From: Suzanne Jones
Sent: Thu, 17 Dec 2020 14:18:10 +0000
To: Planning Inbox (FODDC)
Subject: FW: P2128/20/FUL- Dean Pool Court, Clearwell

I would be grateful if you could confirm that the following description of development is acceptable "Erection of a single storey wooden cabin for use as a holiday let."

Location Plan

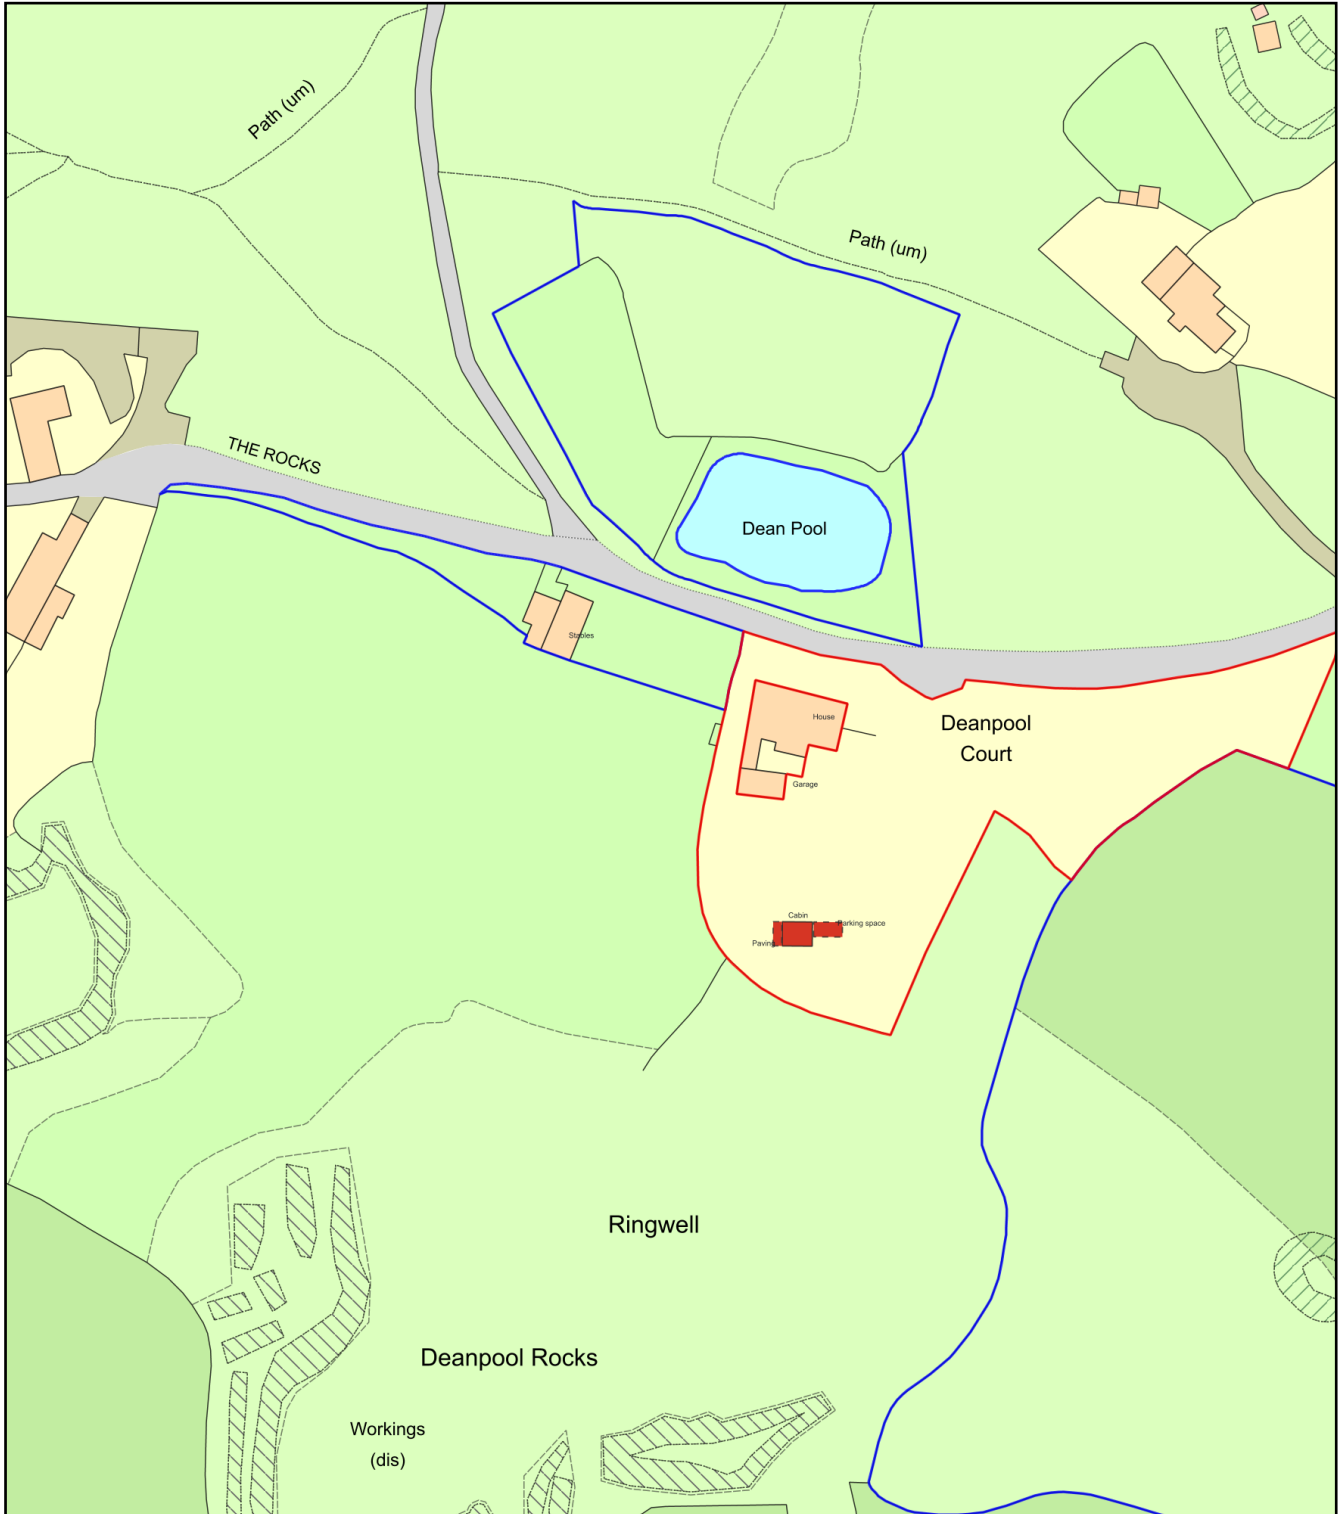
- The location plan will need to be amended so that the residential curtilage is outlined in red, this will include the house and domestic garden area only, all other land will need to be outlined in blue to indicate ownership.
- The accommodation proposed will need to be shown on the floor plan.
- A terrace area is proposed, details of this will need to be provided, either metric scaled drawings or drawn with the metric measurements annotated, if attached to the building this will need to be shown with the elevations.
